Objection to Planning Application FP/46/15/HH

Ref: Planning Application FP/46/15/HH

ROOF PLAN PROPOSED 1:100

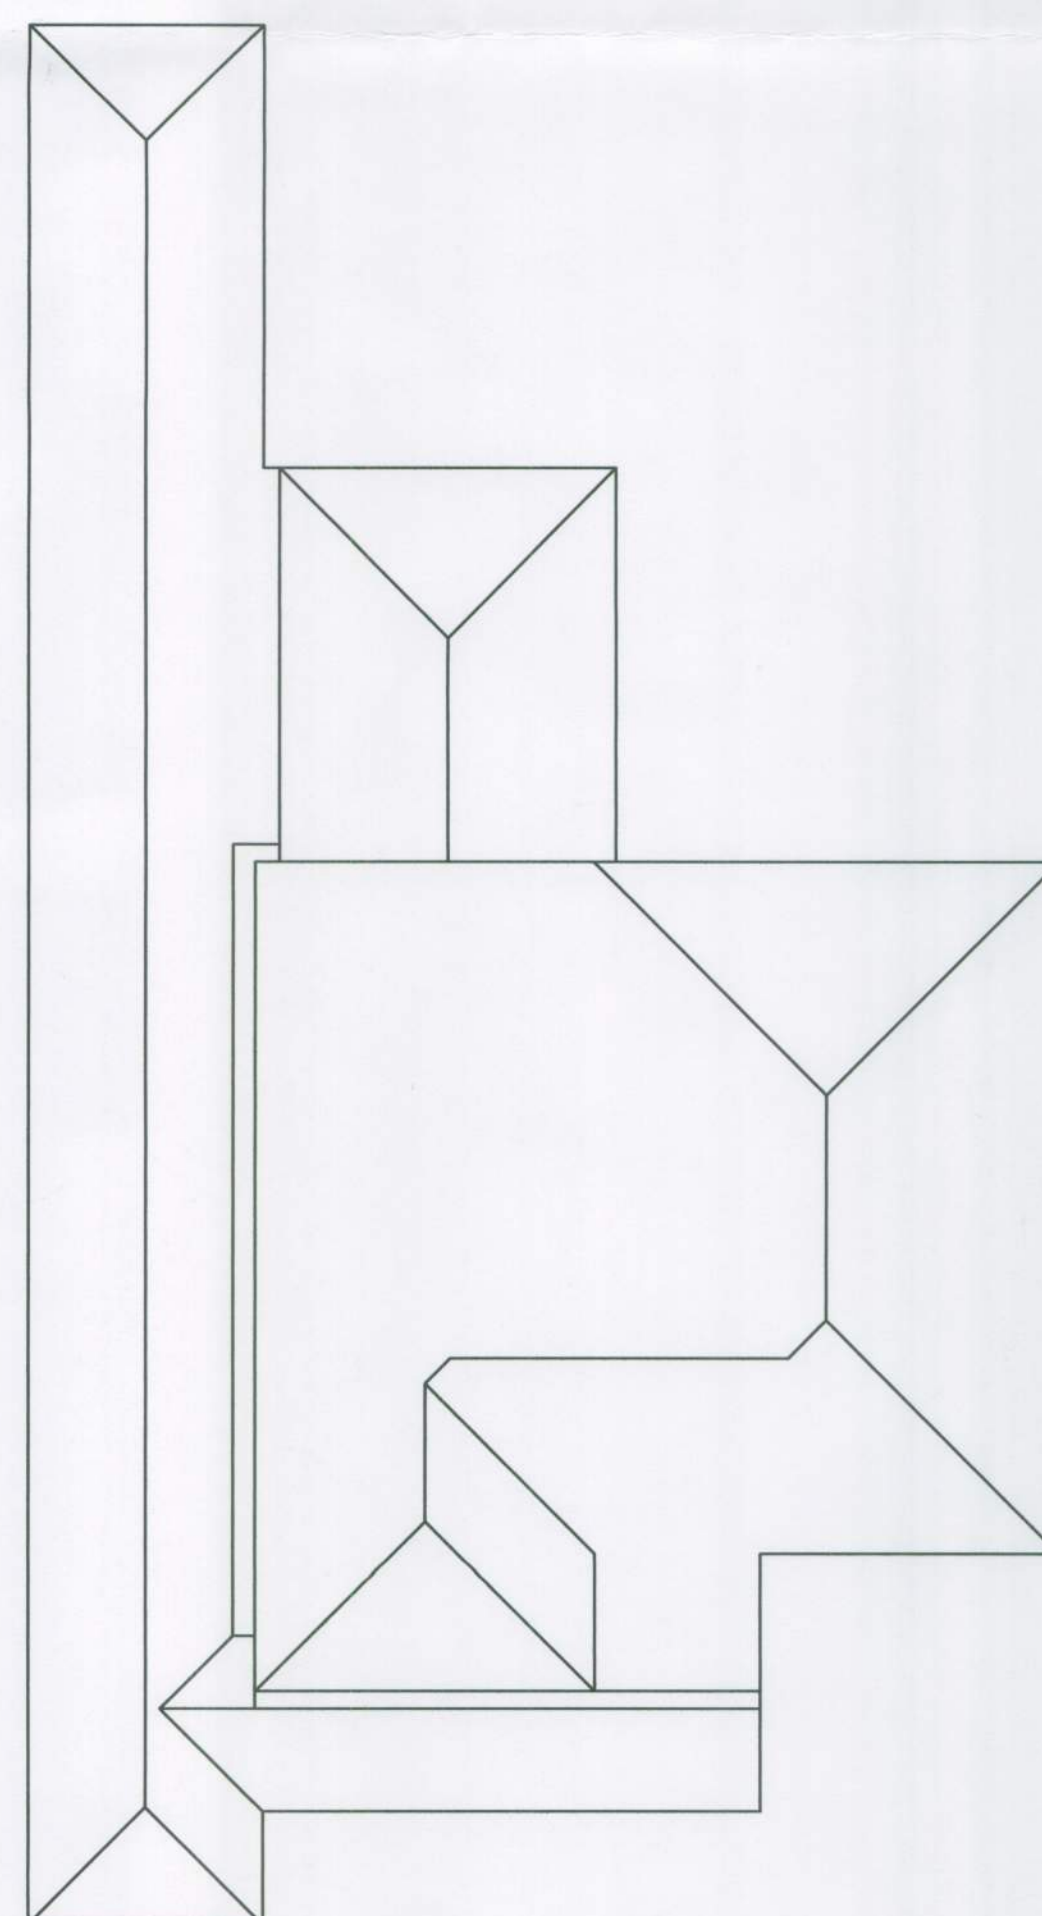
1. Due to the very close proximity of the proposed car-port roof and gutter to our garage it would make it impossible for us to carry out general maintenance to the west side of our garage.
2. Any window facing our property, be it clear or opaque glass, open or closed, is not acceptable. May we suggest a modest alteration to your plan to site the WC adjacent to your back garden.
3. Any exhaust of washing/drying air should be extracted through the west side of the proposed utility room.
4. We shall require assurances that water drainage from the vast roof area will be main drainage and not soak-away in recognition of the 2012 Felpham floods which resulted in our back garden being under water.
5. Access via our garden will be limited to protect our plants and shrubs so please give this your careful consideration before building commences.
